From:
Sent: 12 October 2026 15:52
To: DC Admin
Subject: Application No, 2026/92441 Netherton to Crosland Factory Greenway

We would like to make the following representations as a resident of Fold Farm Lane.

TITLE FOLD FARM LANE TIE-IN

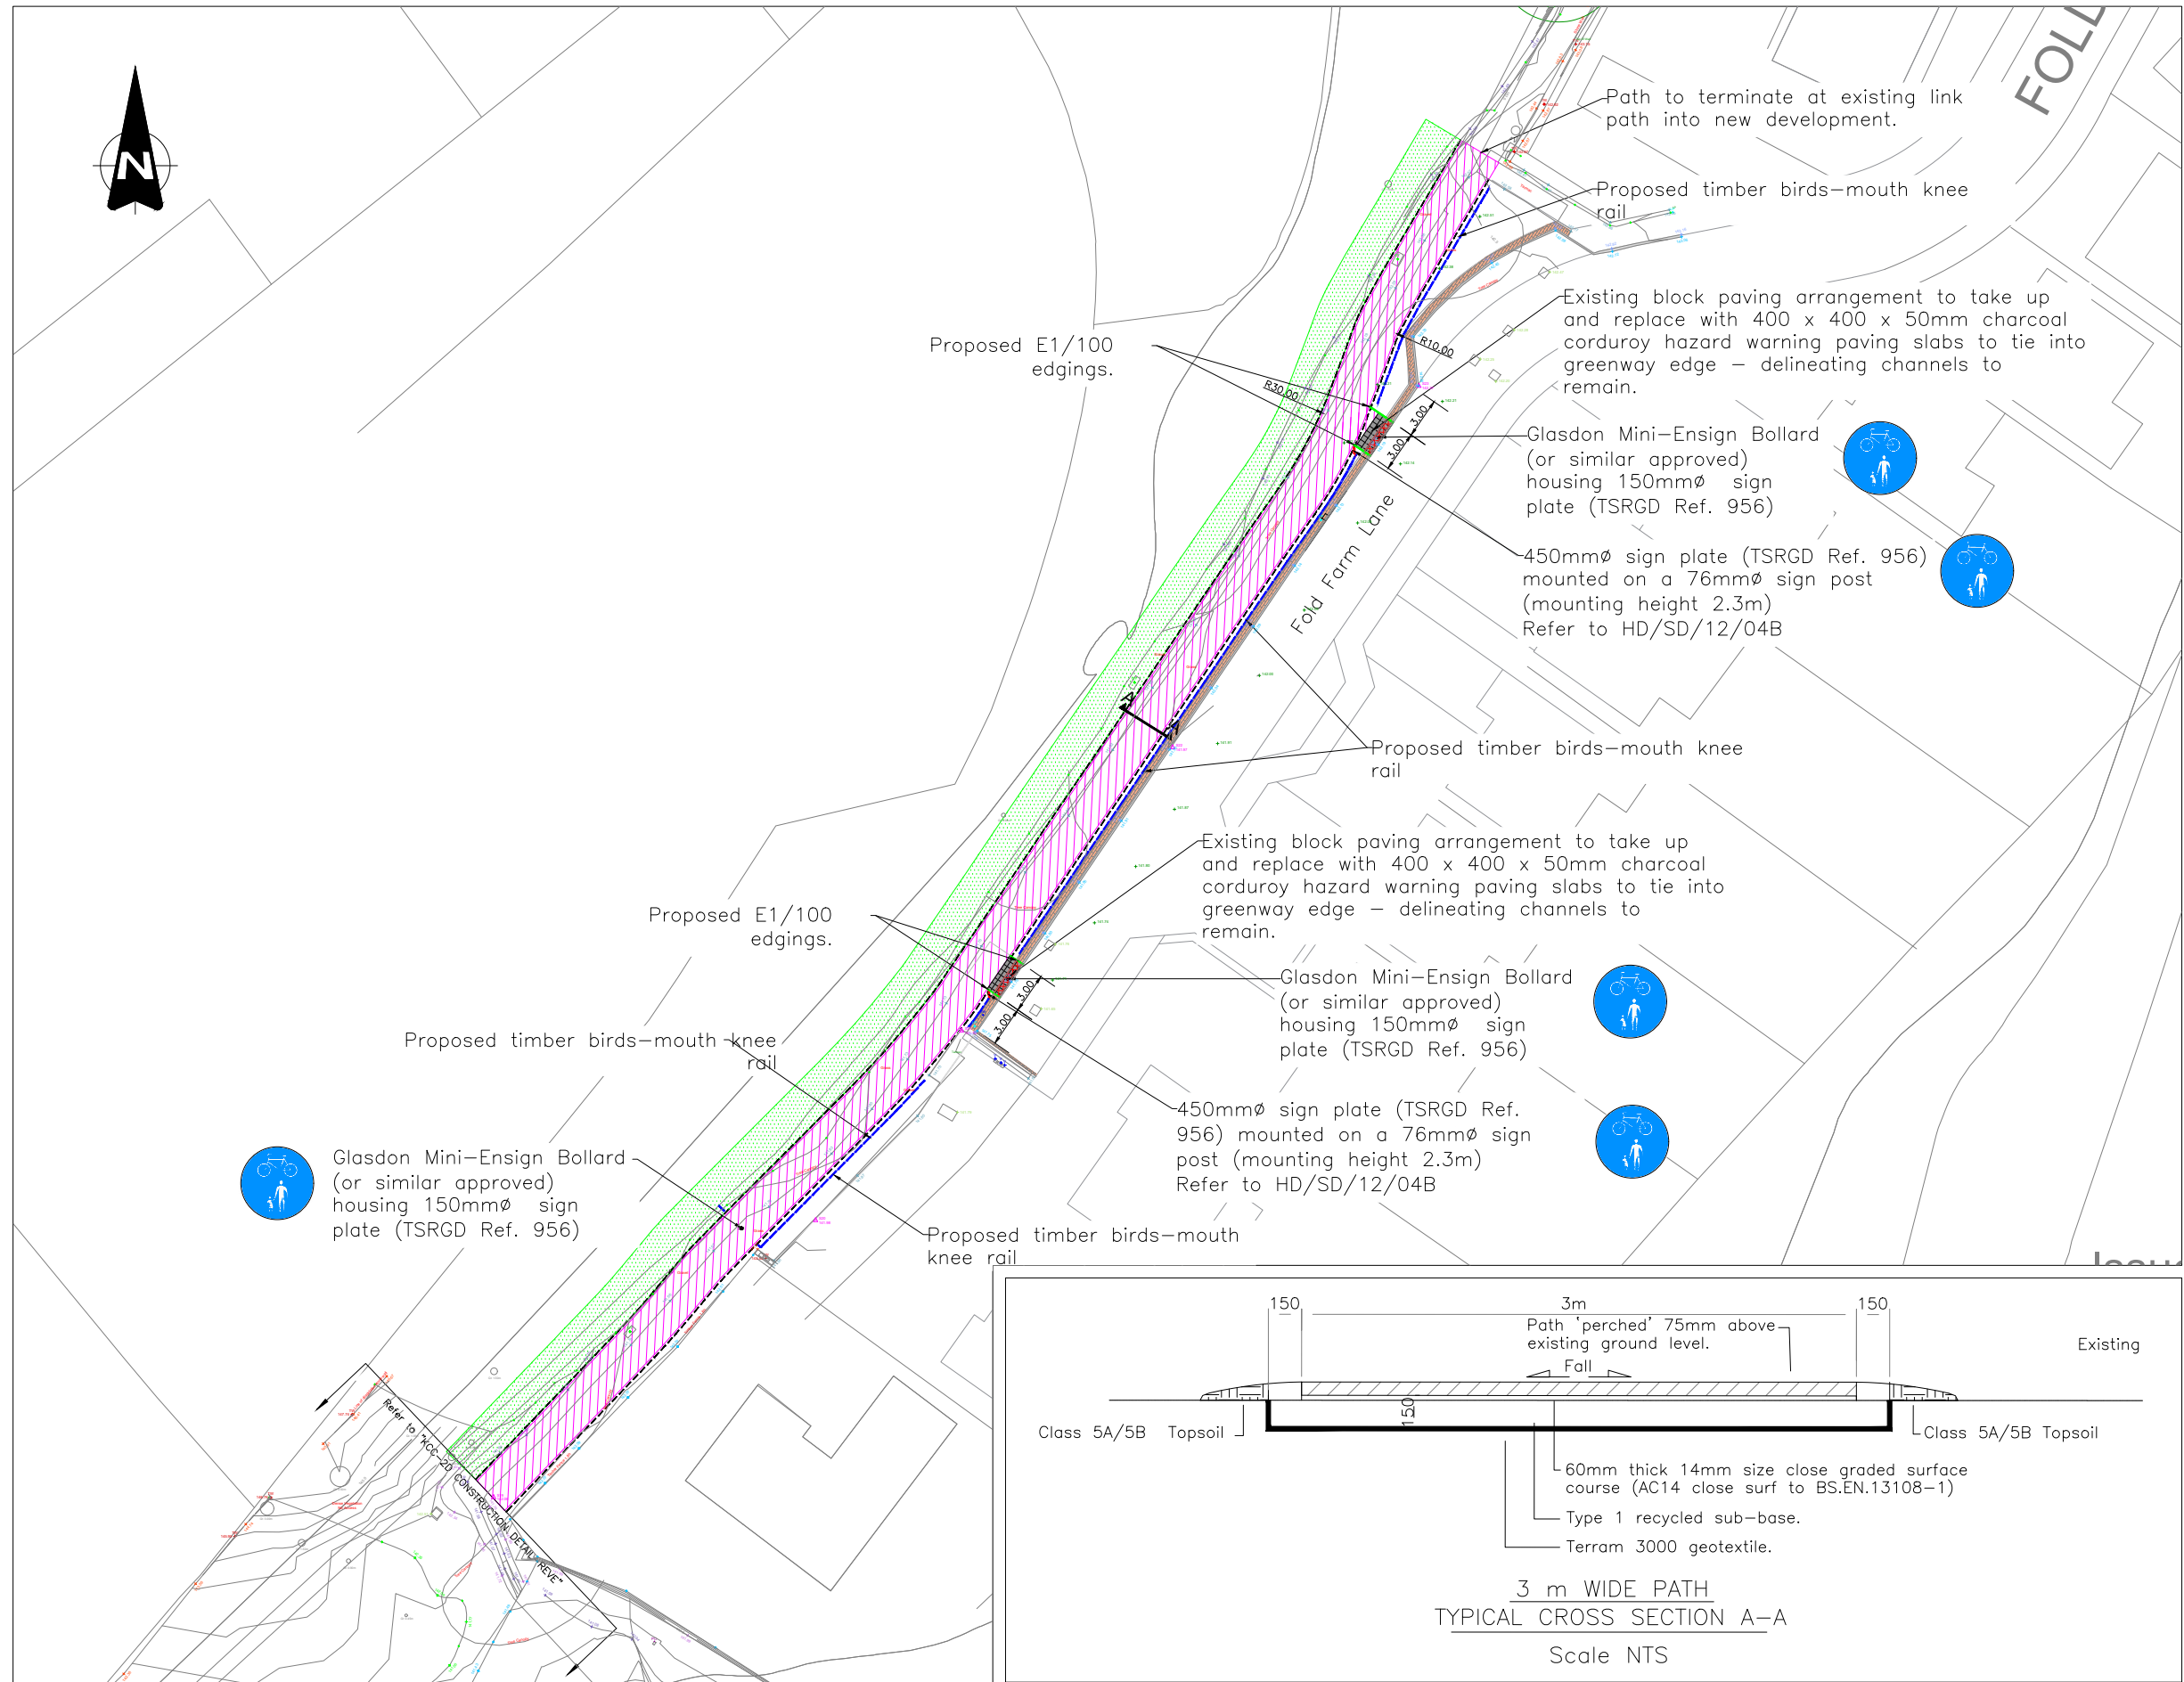
Where do you expect most users of the greenway will access the path, at the Fold Farm End or Crosland Factory? There is currently casual use of the path by walkers who make their way on foot. I envisage when cycling is allowed users will turn up in cars and decant their occupants and bicycles. The developer of Fold Farm Lane included 2 parking bays between the two access points marked on the plan which have room for 4 cars and also a turning bay used by large vehicles such as the dust bin wagon. There are currently no road markings on Fold farm lane so if this is not addressed in the application I can guarantee that the residents will suffer from inconsiderate parking with most concern being that they block the turning bay. I therefore recommend that double yellow lines are placed on all areas apart from the two parking bays together with the appropriate signage.

We currently enjoy seeing deer and nesting owls along our section of the embankment. Also the sheep that are in the fields either side of the proposed greenway often escape onto Fold Farm lane. A knee high birds-mouth rail is not going to deter them from escaping in future but may actually facilitate it if you remove the existing gate just outside our development. You should therefore consider fencing and gates between the fields and the entrance from Fold Farm.
